From: M Burke <burkepostoffice@gmail.com>
Sent: Monday, April 1, 2024 4:16 PM
To: Bradley Gasawski
Subject: Re: VA-24-00001 Burke - Transmittal of Comments

Bradley (Kittitas County Community Development Services)

SITE PLAN
1" = 20'
8.5 X 11 SHEET

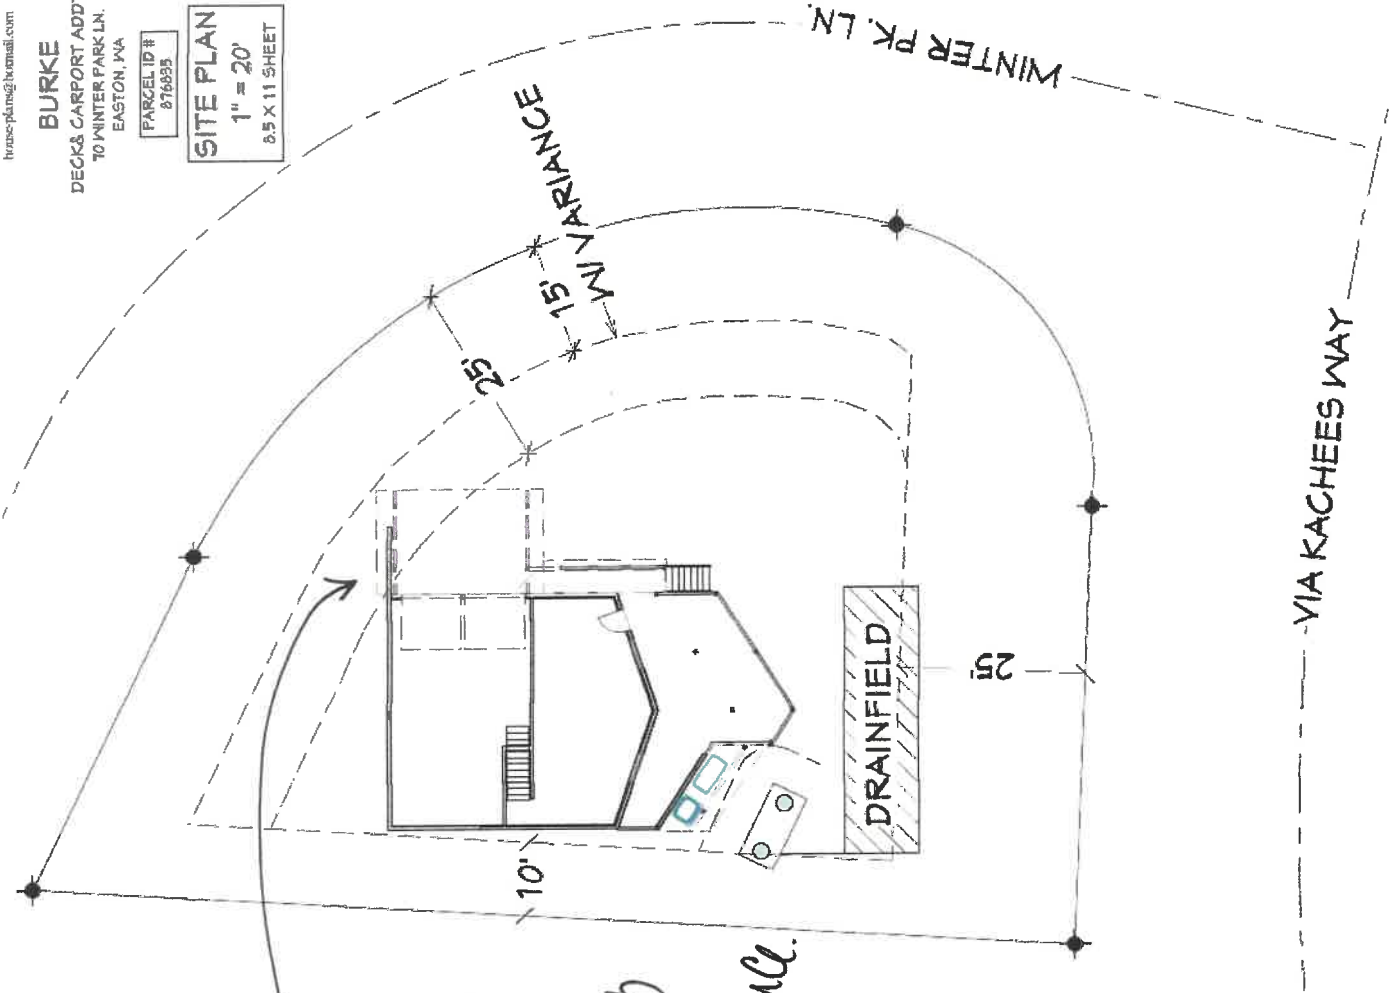
1. **Concrete Wall:** There will be no construction of a concrete wall. One was built during the initial construction years ago and remains in place.
2. **Stabilization Posts:** Stabilization posts will be necessary (2 - 3), but they will be placed over existing driveway asphalt. Ground-disturbing activities will be minimal since the area is already covered with asphalt.
3. **Ground Disturbance:** We will not be installing septic systems, scraping the driveway, or engaging in any other type of ground-disturbing activities.

The proposed overhang design is simple and aimed at ensuring access to our garage during winter snow months. The variance from 15' to 25' necessitated our application for a variance exemption. Our intention was to replace our existing inadequate 5' overhang with a new one measuring 12'. Only a portion of this new overhang would encroach into the new 25' variance, only due to the curvature of the road. Our goal is simply to utilize our garage during winter months with this updated overhang. Lastly, the new overhang only extends over our existing asphalted driveway and does not affect or cover anything else; it merely occupies a small portion of our existing driveway.
